**From:** [REDACTED]  
**Sent:** 26 October 2023 11:23  
**To:** Planning  
**Subject:** Planning Application 3/2023/0664

I am writing to oppose planning application 3/2023/0664 at grid reference 369072 434193. This refers to Langho Sports and Social Club's attempt to construct dugouts.

We write to you regarding the proposal to construct two dugout shelter buildings to replace the existing temporary shelters at Langho Sports & Social Club, Dewhurst Road, Langho, BB6 8AF.

**1\* Proposed Ground Floor Level Plan**  
1:20

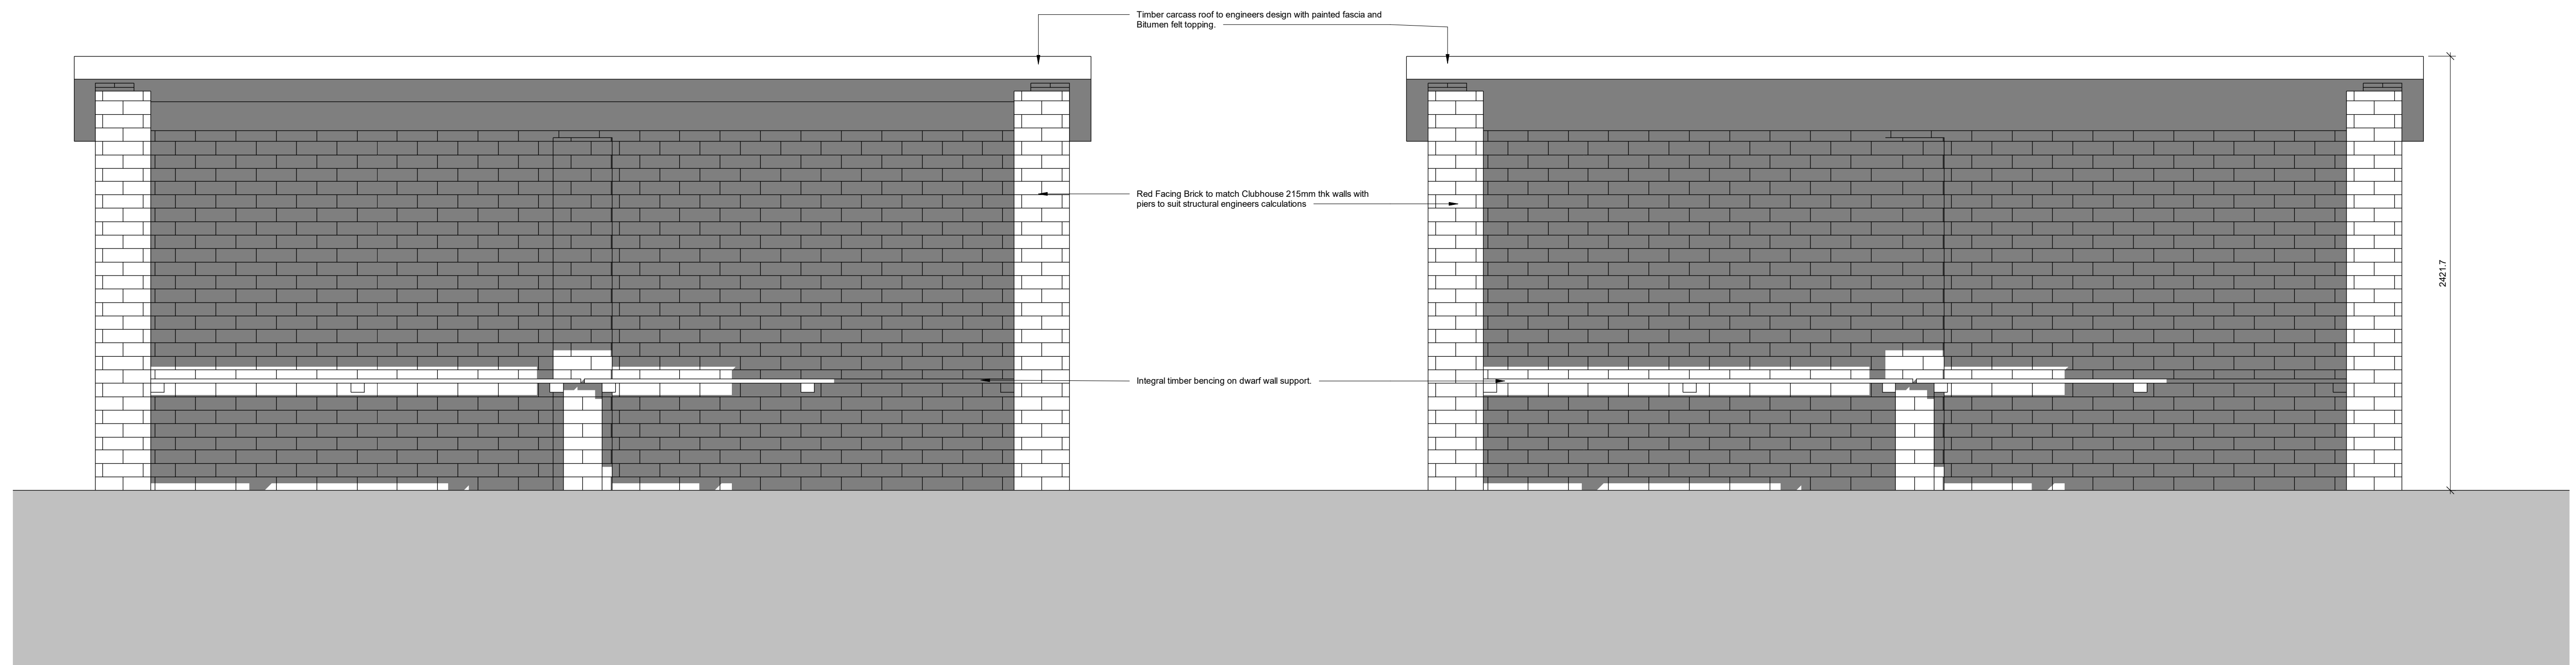
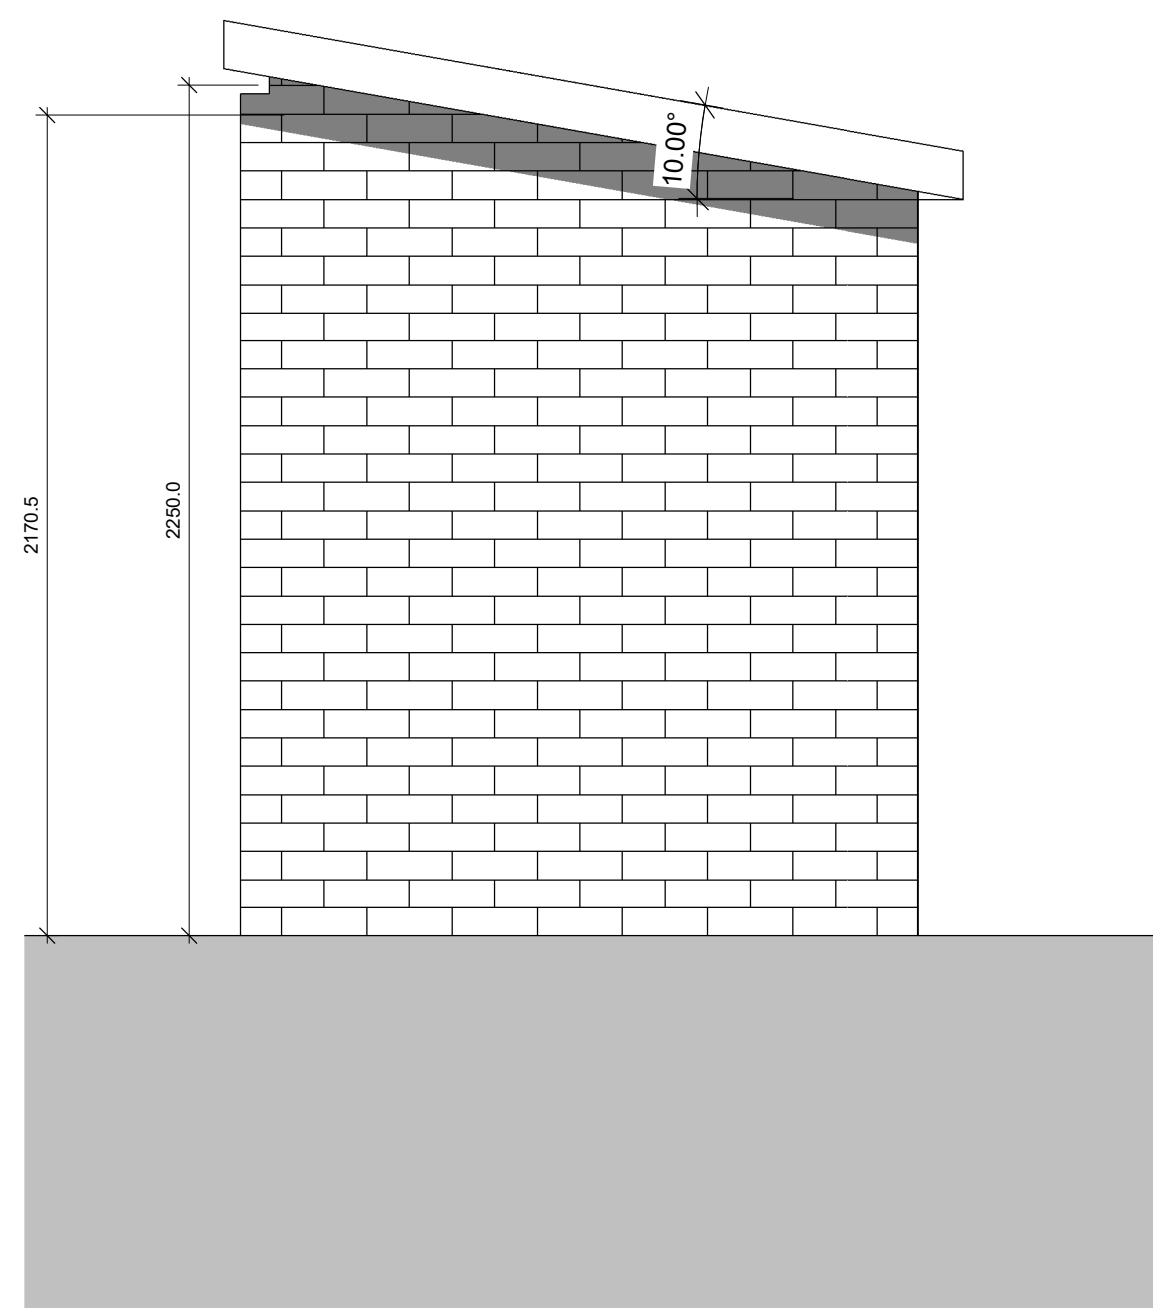
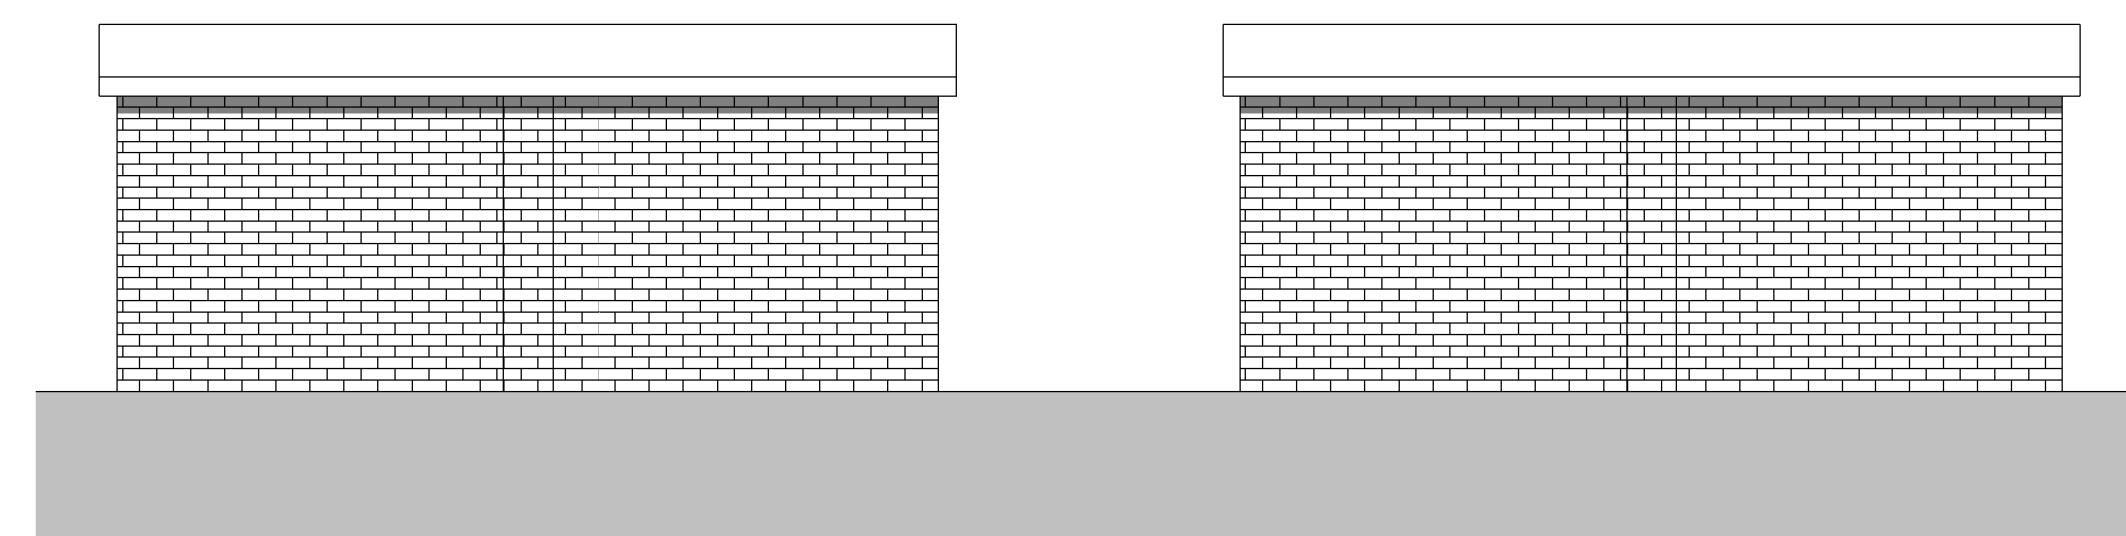
The development is not sympathetic to its surroundings in terms of size, massing, materials and scale. Creating two permanent brick structures each measuring 5.43 metres long; 2.42 metres high and 1.79 metres wide would significantly alter the look and feel provided by the smaller, portable and transparent facilities that currently exist and as such, would completely diminish the striking, pleasant and open plan aspect currently enjoyed by all local residents and visitors.

- The current temporary shelters are significantly smaller, each measuring 2.51m long x 0.91m wide, compared to the proposed structures which measure 5.43m long x 1.79m wide. The proposed structures would take 19.44m<sup>2</sup> away from the Community Public Open Space. This is a considerable portion for the number of houses compared to the amount of open space available without having to go down onto the A59.

Langho FC The Rydings proposed site plan

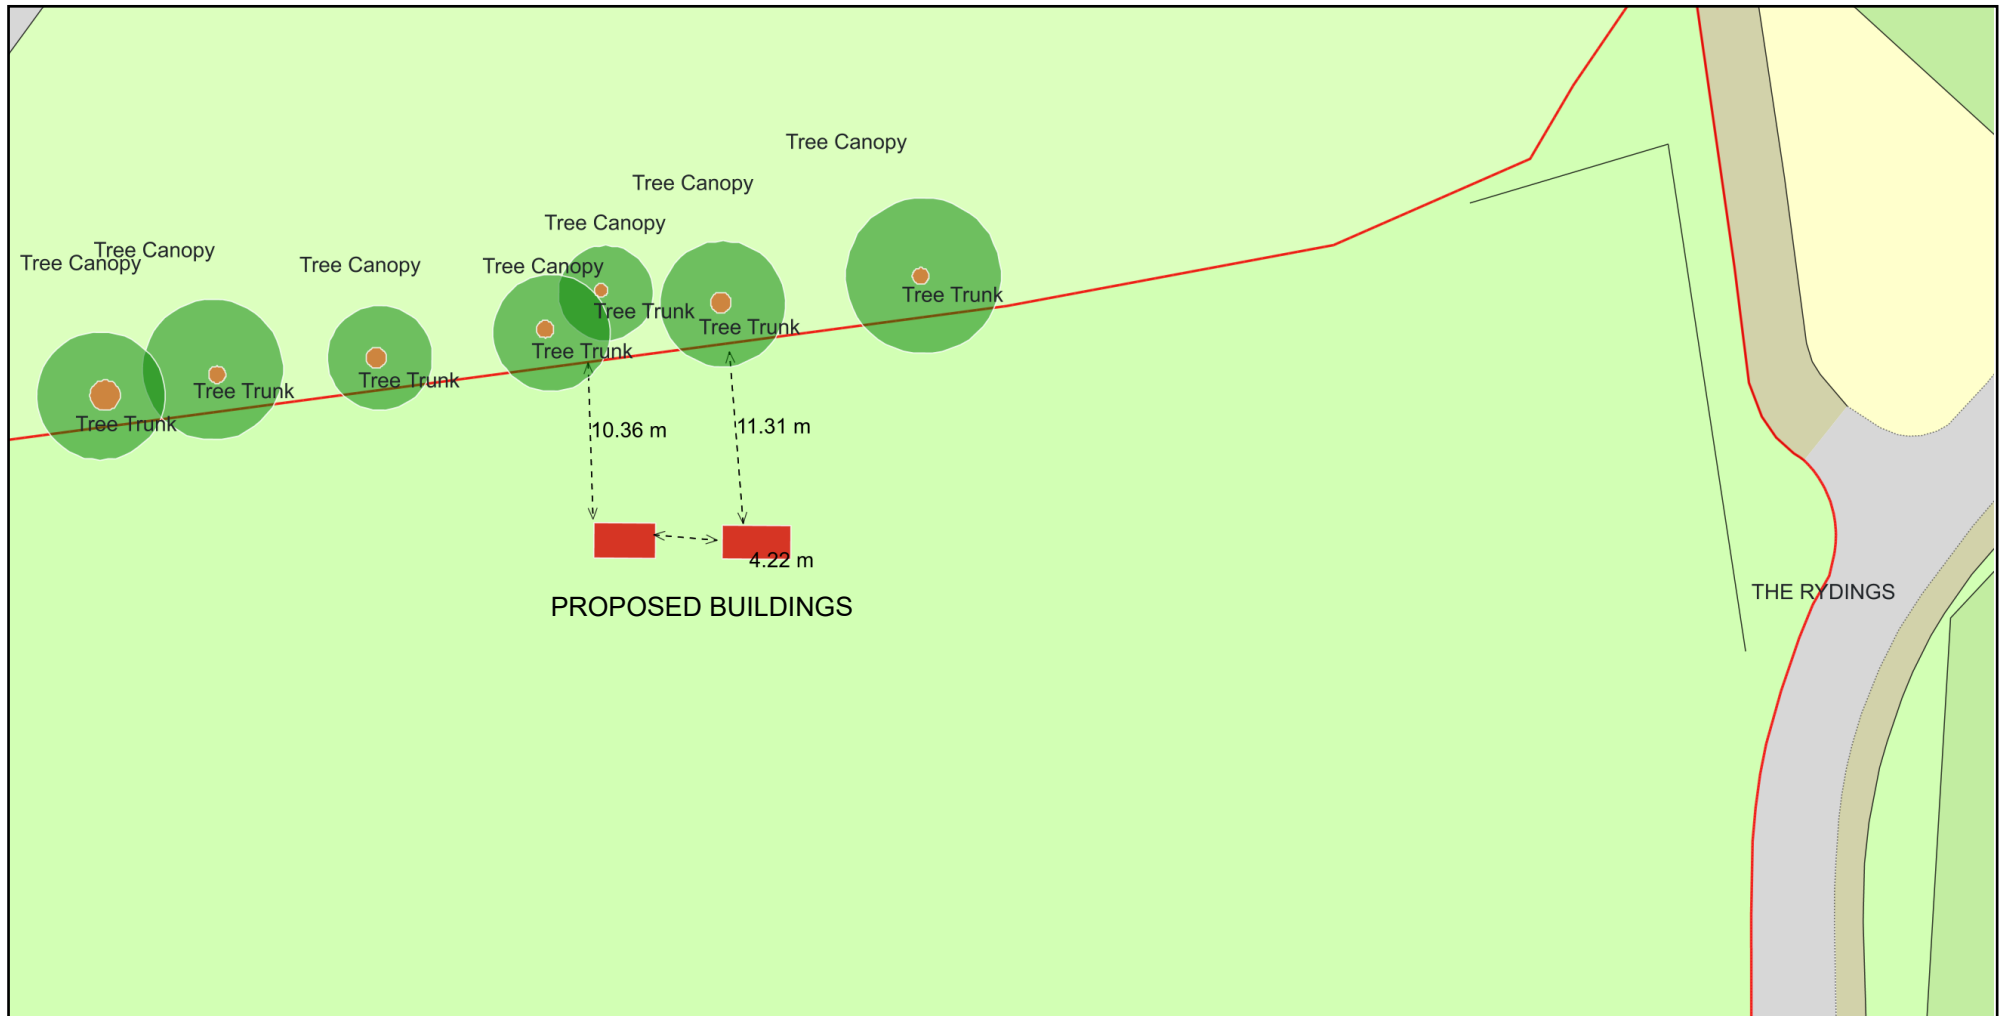
The proposed buildings would look completed out of character being isolated in the centre of the open area, albeit towards the bottom of the public open area. The size and permanent nature of these structures would spoil the natural beauty of the area.
